**Addendum No. 1**

RE: Contract ID C202763

WBS # 5CR.10921.31

US-1 (Capital Blvd.) From Hodges Street To North of Sumner Blvd. in Raleigh

PROJECT NO.	SHEET NO.	TOTAL NO.
5CR.10921.31	3

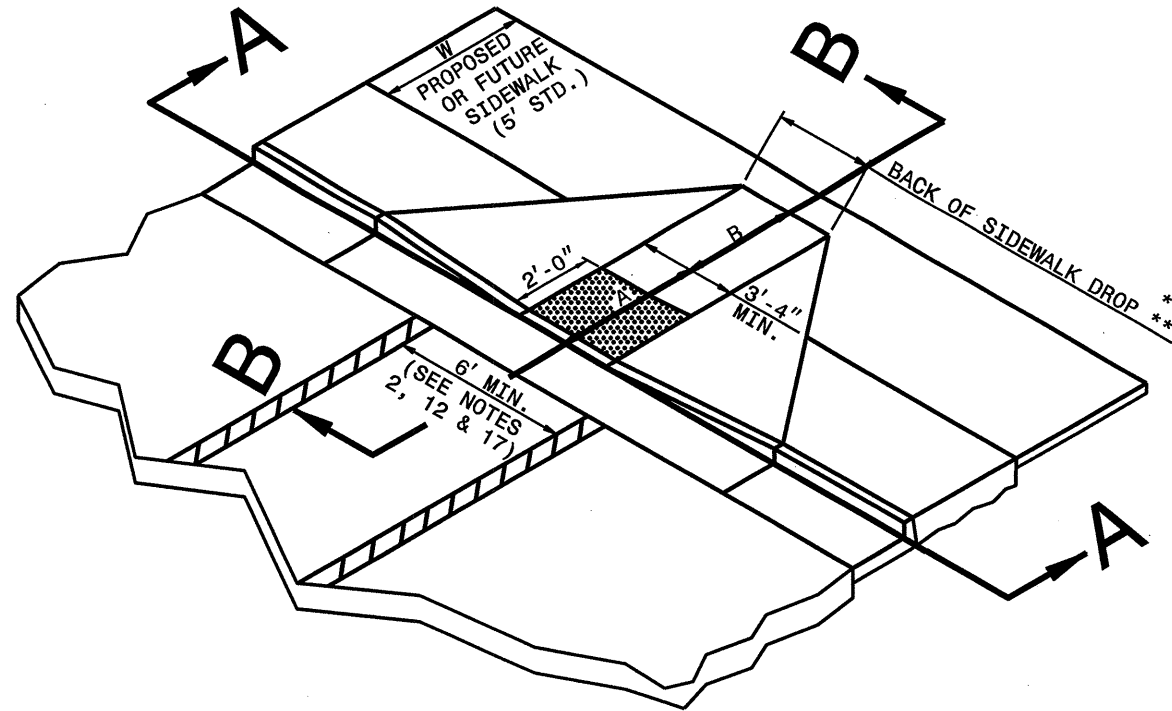
Sheet No. 3 has been revised to reflect the below noted pay item additions. Please void Sheet No. 3 in your plans and staple the revised Sheet No. 3 thereto.

<u>Item</u>	<u>Description</u>	<u>Old Quantity</u>	<u>New Quantity</u>
33-283000000-N-858	Adjustment of Manholes	NEW ITEM	21 EA
34-284500000-N-858	Adjustment of Meter Boxes and Valve Boxes	NEW ITEM	26 EA
